From: Josh Pozzobon <josh@builtprefab.com>
Sent: Tuesday, September 9, 2025 11:30 AM
To: Ellie Myers
Cc: Ian Garrity; Jamey Ayling
Subject: Re: SX-25-00013 Schwartz - Shoreline Exemption Deemed Incomplete

Planner I | **Kittitas County Community Development Services**

SITE PLAN

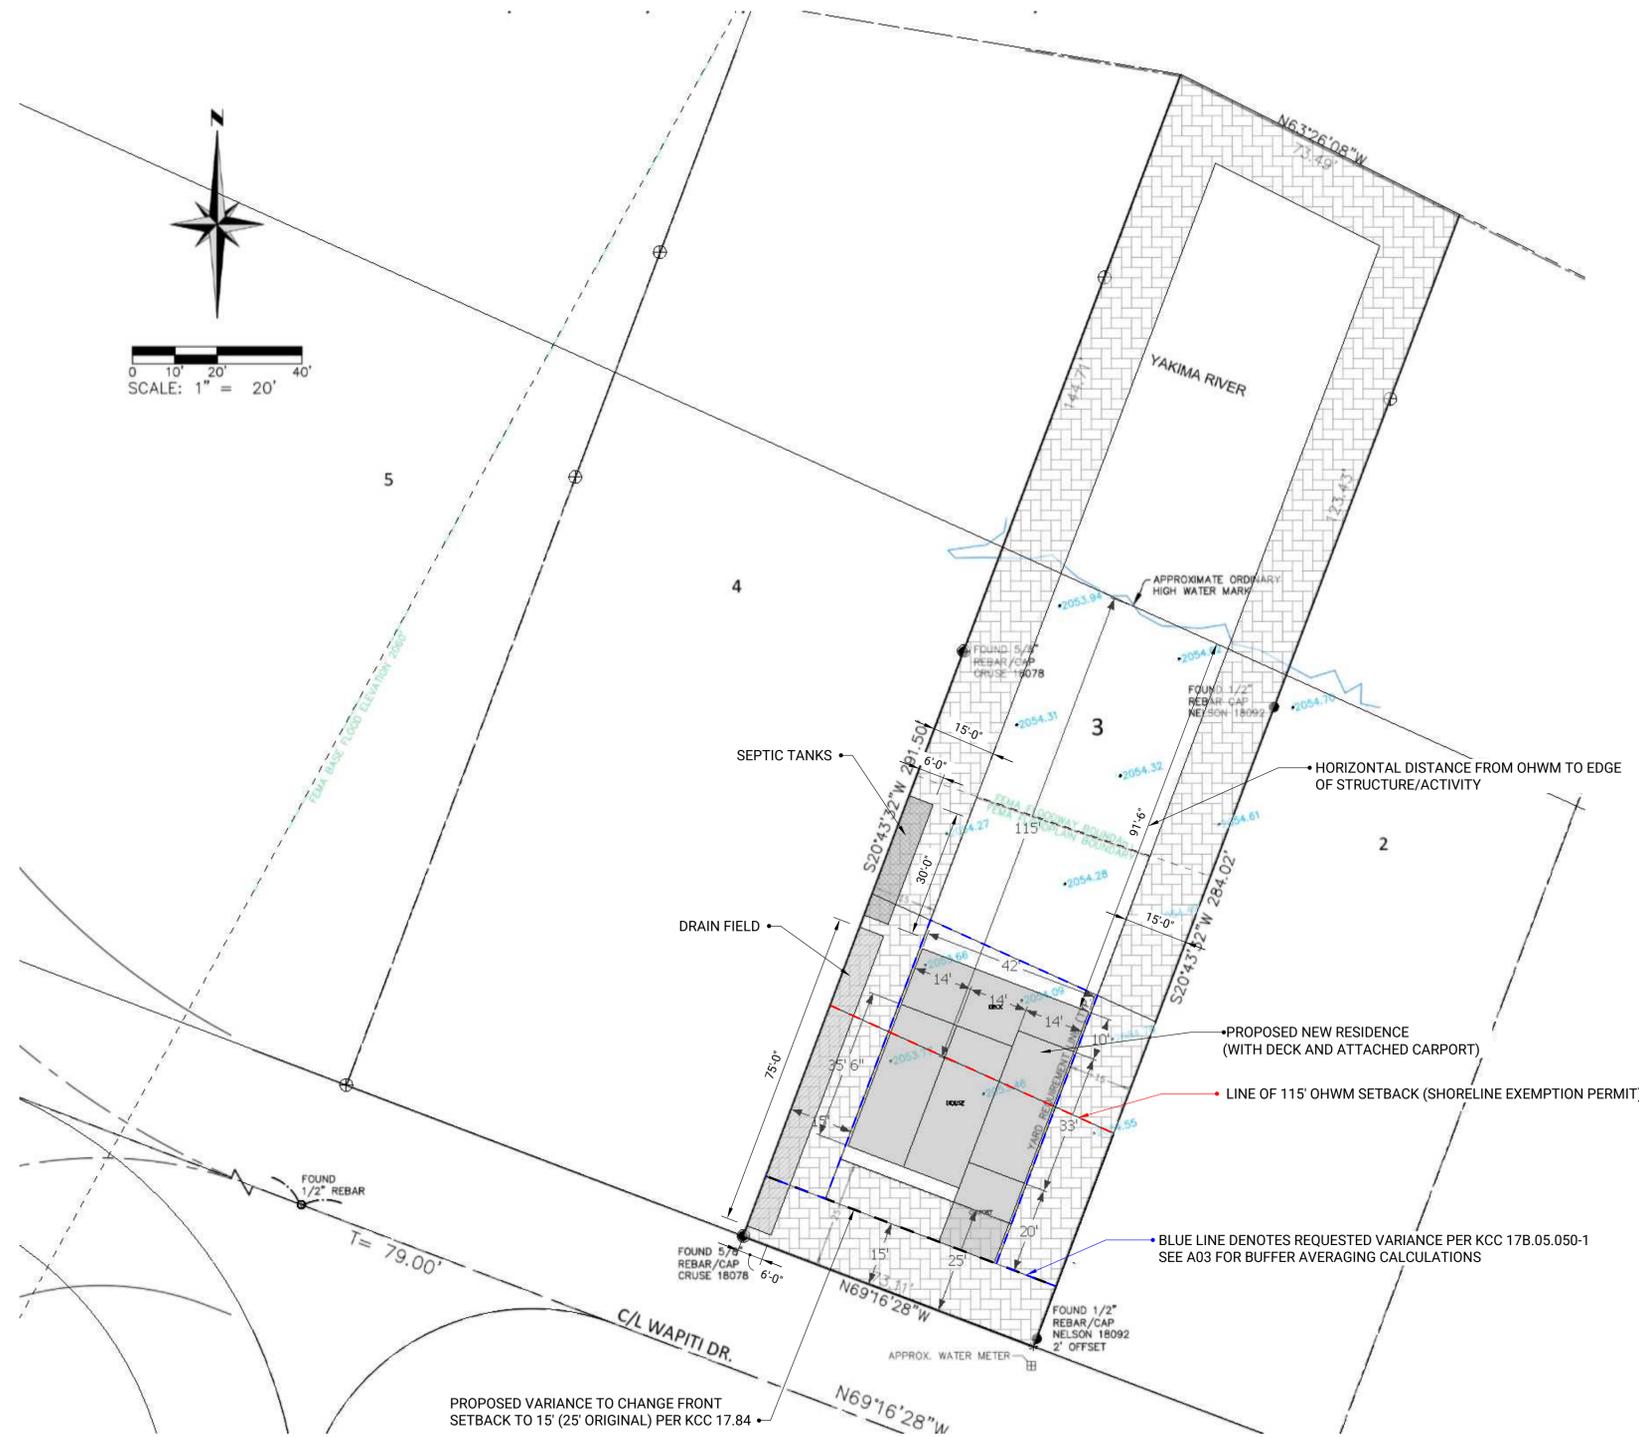
The buffer area being increased must start at the 115-foot buffer, not before. I'm sorry, but development must be outside the 115-foot buffer unless buffer averaging is used. When buffer averaging is used the buffer shall be increased from the 115-foot buffer in another location, of equal area.

It can be done, but you'll need to offset the reduction by increasing the buffer elsewhere. Since you're already proposing buffer averaging to reduce the setback for part of the house and the deck, I'm concerned there may not be enough available space to also accommodate a reduced buffer for the septic system. Is there sufficient room on the east side of the lot to make up for all of this?

We also need the Critical Aquifer Recharge Areas report (KKC 17B.05.020W) completed before we can continue processing the Shoreline Exemption if buffer averaging is going to be used.

Buffer averaging can still only be used to reduce the buffer width by 25% of the standard distance. So, you could use buffer averaging to reduce the buffer down to 75 feet, but there's still the 15-foot building setback per KCC 17A.01.090(4). That 15-foot setback can also be reduced by 25%, so the total distance the buffer could be reduced is 86.25 feet.

Neither tank or drain field can be placed in the 115-foot buffer.

It looks like the septic tank is still within the 115-foot buffer.

Right now, the septic tank is shown about 60 feet from the Ordinary High Water Mark (OHWM), and the drain field is located within the proposed compensatory buffer averaging area. The layout needs to be designed so that all development stays outside the shoreline buffer. This would allow us to avoid the shoreline variance process, which is lengthy and ultimately decided by the Department of Ecology, and I can't guarantee it would be approved.

1. Placing the septic system and drain field in front of the house.
2. Move the house forward (closer to the front setback) and place the septic system behind it.

CDS would allow a 10-foot reduction to the front setback with a zoning variance to help avoid the shoreline buffer, which our department can approve internally.

If you go this route, you'd still be able to request up to 600 square feet of encroachment into the shoreline buffer, with a compensatory buffer averaging area of 600 square feet on the east side of the residence. However, this would still require the critical areas report I mentioned yesterday.

Just wanted to update you on our status. We are going to resubmit our Site Plan for the Shoreline Variance per the attached. We have updated the locations of our Septic (which will align with the septic permitting) to be compliant with our Shoreline Buffer. I will also reupload the Letter updated with our consistent language.

Okay, understood. So does the following buffer averaging work? The orange area is the offsetting buffer averaging area, and the green area is the area we are using the buffer at.

And the septic would not go beyond the 115' setback. We can also do some sort of signage for that area on the Eastern PL to ensure no development takes place there.
